SUBMISSION IN RESPONSE TO MODIFICATION APPLICATION
07_0118 MOD1 GULLEN RANGE WIND FARM

Outline of situation re non compliance of Gullen Range wind turbines

Figure 3-4 House locations (houses within 2km)

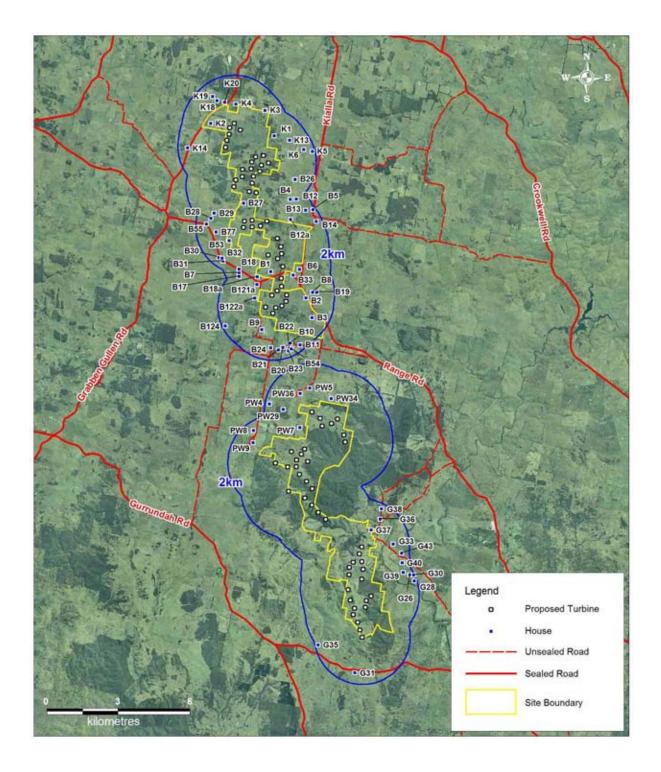
The H & J Price-Jones residence is referred to as B12. According to the modification application there are 5 turbines within 2kms of this residence, the same number as in the original design and BUT the developer's Micrositing Consistency Review Final (December 2013) shows that there are 10 turbines within 2kms of this residence. One of these turbines has been relocated by 187m and 166m closer to this residence as far as can be ascertained.

Turbines BAN 5,6,7,8,11,13,14 and 15 are all exceptionally close to the Glan Aber property boundaries – with Ban 15 having been moved 166m closer to the boundary and residence. Due to unavailable independent survey information, the precise distance from these turbines to the boundary and the residence cannot be precisely ascertained and therefore neither can the full extent of the negative impacts created.
